From: Martyn White <Martyn.White@arun.gov.uk> **On Behalf Of** Conservation Officer
Sent: 23 December 2025 17:07
To: Planning.Responses <Planning.Responses@arun.gov.uk>
Cc: Rhiannon Lloyd <Rhiannon.Lloyd@arun.gov.uk>
Subject: AB/136/25/L

AB/136/25/L

Houghton House 4 Arun Street Arundel BN18 9DL

Listed building consent for single storey rear extension, alterations to rear roof and internal alterations (resubmission following AB/26/25/L).

Proposed Ground Floor Plan 1:100

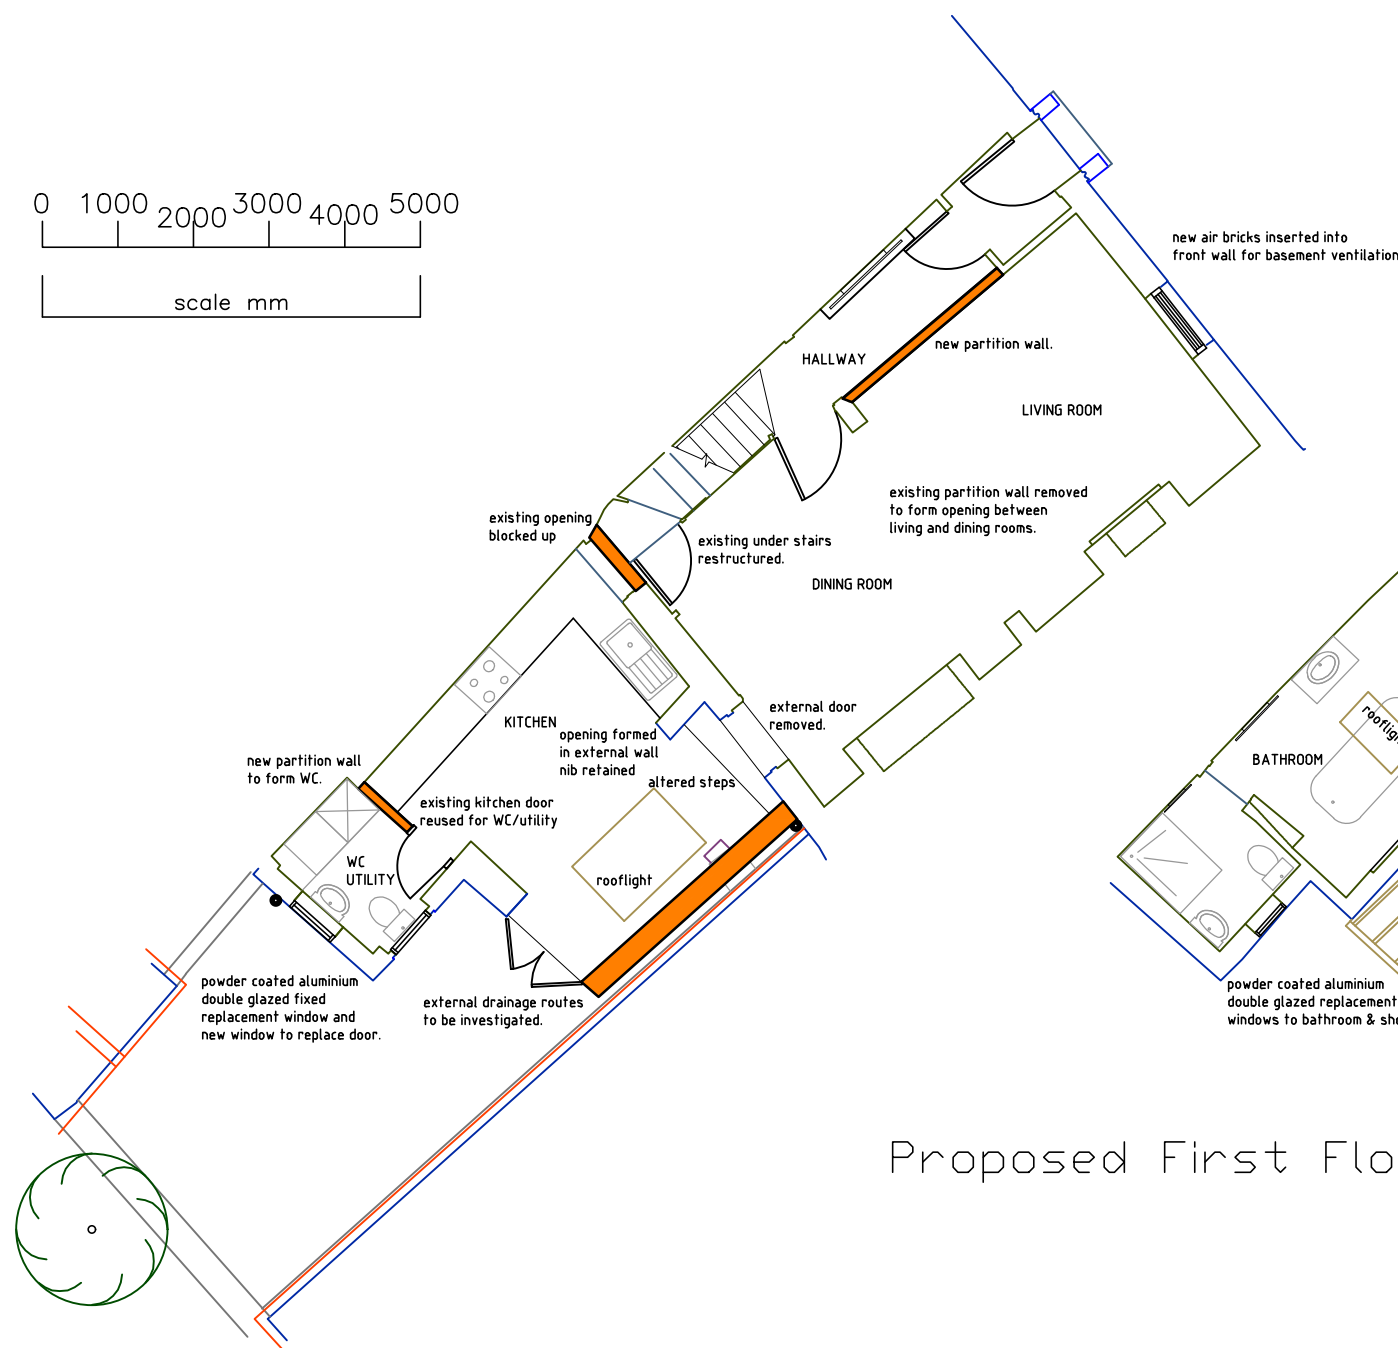
The extension design is well considered, featuring a simple roof form that respects existing features, along with a parapet wall with stone coping and rendered walls. The zinc roof with an inset rooflight is a positive element. The removal of external doors and part of the kitchen wall is noted, and the retention of wall nibs is welcomed as it preserves the legibility of the original layout.

DRAWING
**PROPOSED
ELEVATIONS**

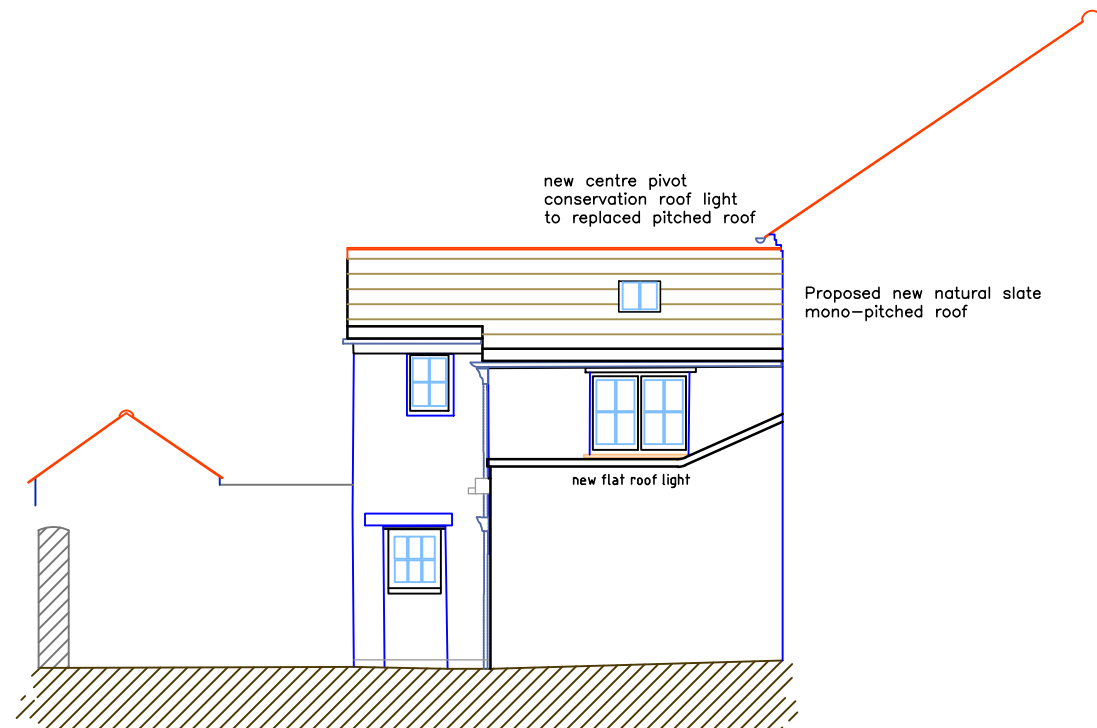
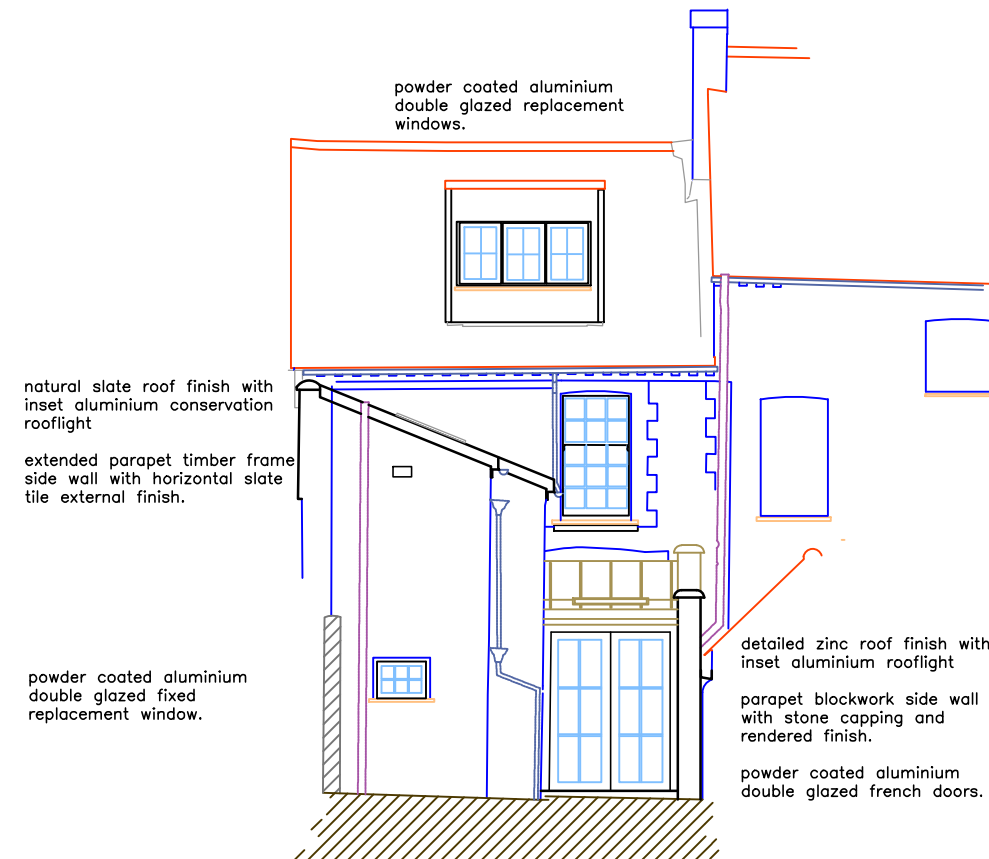
The proposed revisions to the rear windows are acceptable in light of these specific circumstances. This decision does not set a precedent for other schemes within the town. However, it is not fully clear what the sash window will look like - there is no clear section detail, and it is unclear whether it will be a functioning sliding sash or a top-hung casement. The latter would not be acceptable in a listed building. Further information and clarification are required.
